Subject: FW: OBJECTION TO PLANNING APPLICATION AW/337/19A - OBJECTION TO ONE STOP STORE APPLICATION FOR SIGNAGE ON THE SHIP INN SITE

Please upload as rep letter for AW/337/19/A

Subject: OBJECTION TO PLANNING APPLICATION AW/337/19A - OBJECTION TO ONE STOP STORE APPLICATION FOR SIGNAGE ON THE SHIP INN SITE

PROPOSED SITE SIGNAGE

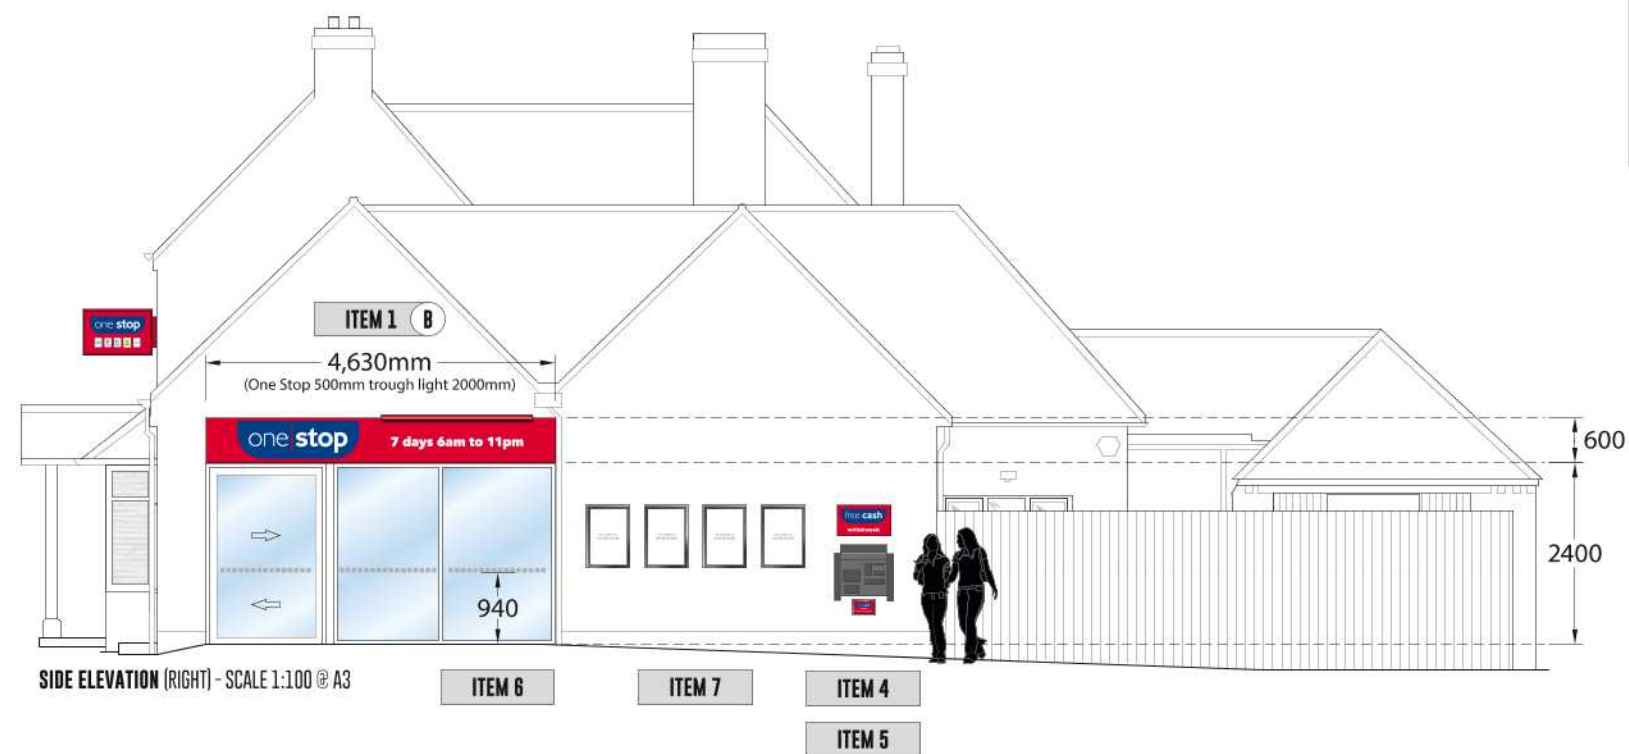
Therefore, we totally reject the above planning application because it is obtrusively bright and lurid in nature and not in keeping with the local surroundings.

With regard to the proposed lighting, One Stop are selfish in that they do not care that they will be causing night time pollution to the surrounding areas, with the potential of the lighting never being turned off.

We are also unhappy with the proposed signage and lighting in the car park, which is very small, again One Stop show they do not care at all about the safety of local residents and drivers.

PROPOSED SITE SIGNAGE

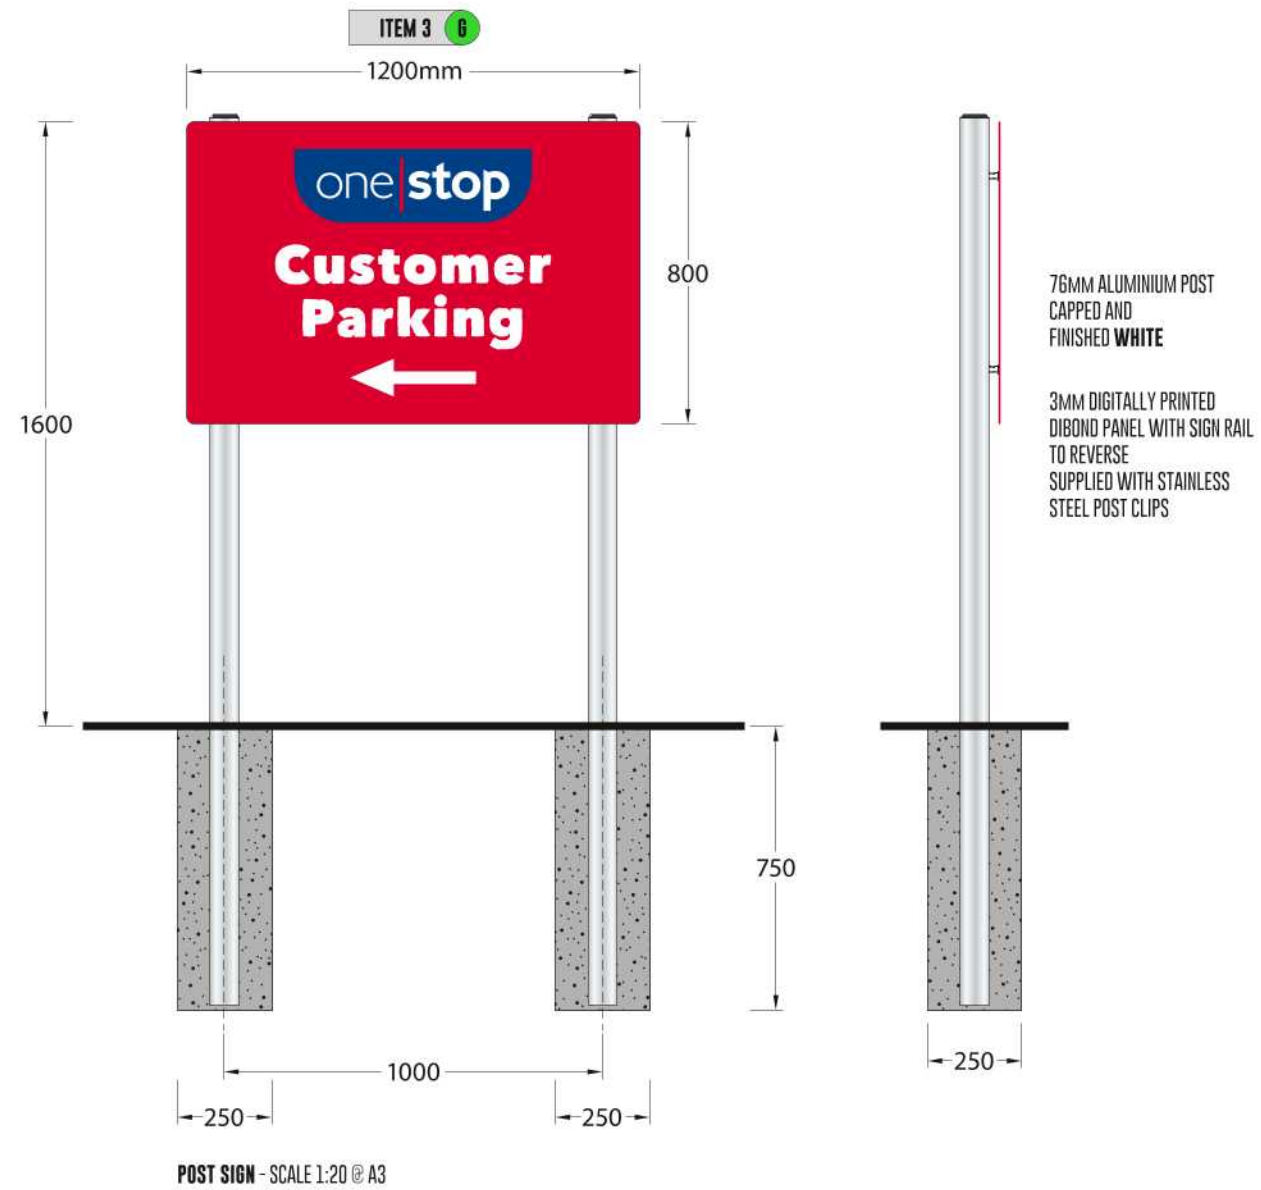
In addition, the proposed panels covering the bay windows are truly awful. Once again this is a small village, not a metropolis.
